City of Albuquerque

November 29, 1990

RE: DRAINAGE PLAN FOR ALBUQUERQUE FAMILY HEALTH CENTER
(J-14/D94) RECEIVED NOVEMBER 19, 1990 STAMPED NOVEMBER 16, 1990

DRAINAGE AND GRADING PLAN

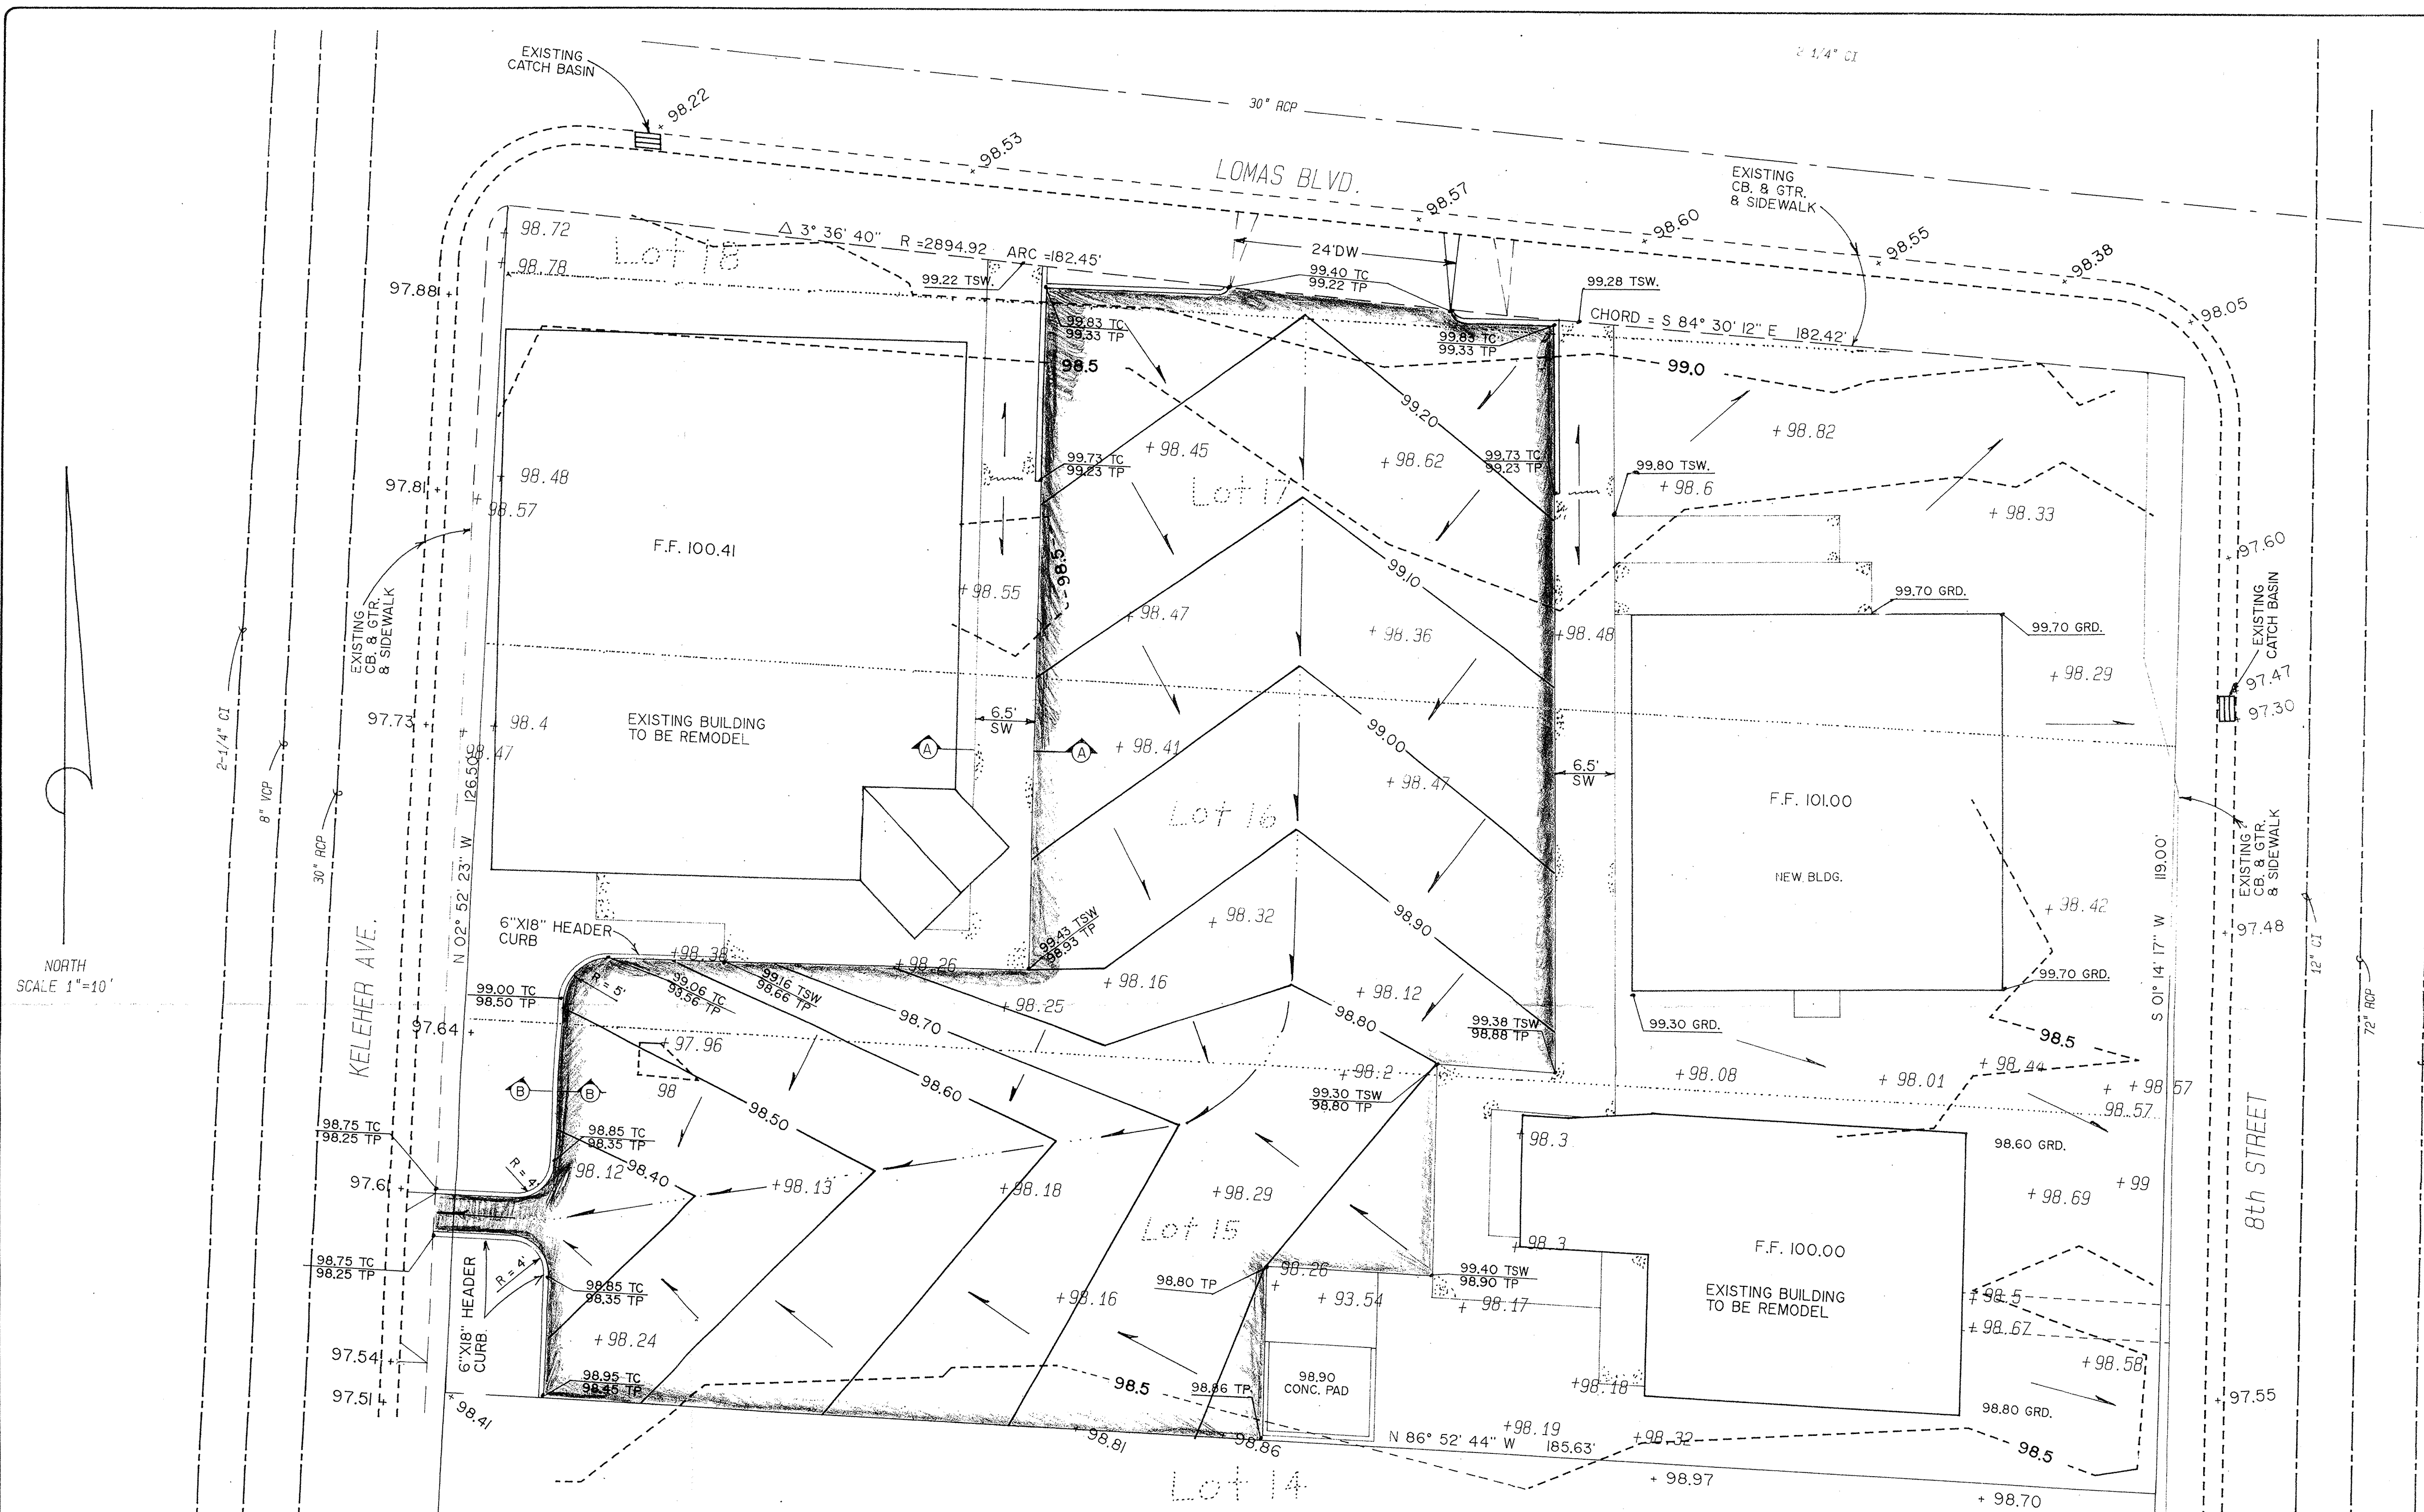
1. Elevation at property line must be 1' above flow line.
2. Proposed concrete channel must tie into a sidewalk culvert. S.O. #19 process must be used. Please include the six notes to contractor along with the sign-off block from the S.O. #19 format within the plan drawing. You must reference the spec number for the culverts.
3. Please include the hydraulics for the sidewalk culvert and channel. Use the weir and orifice equations.
4. Finish floor elevation must be to full mean sea level designation.
5. Please include the elevation for B.M. 17-J14.
6. Need top of curb and flowline elevations on Keleher, Lomas and Eighth.
7. Please include location of roof drains.
8. All developed runoff from the roof areas must be directed to the asphalt area. No developed runoff will be allowed across the public sidewalks.
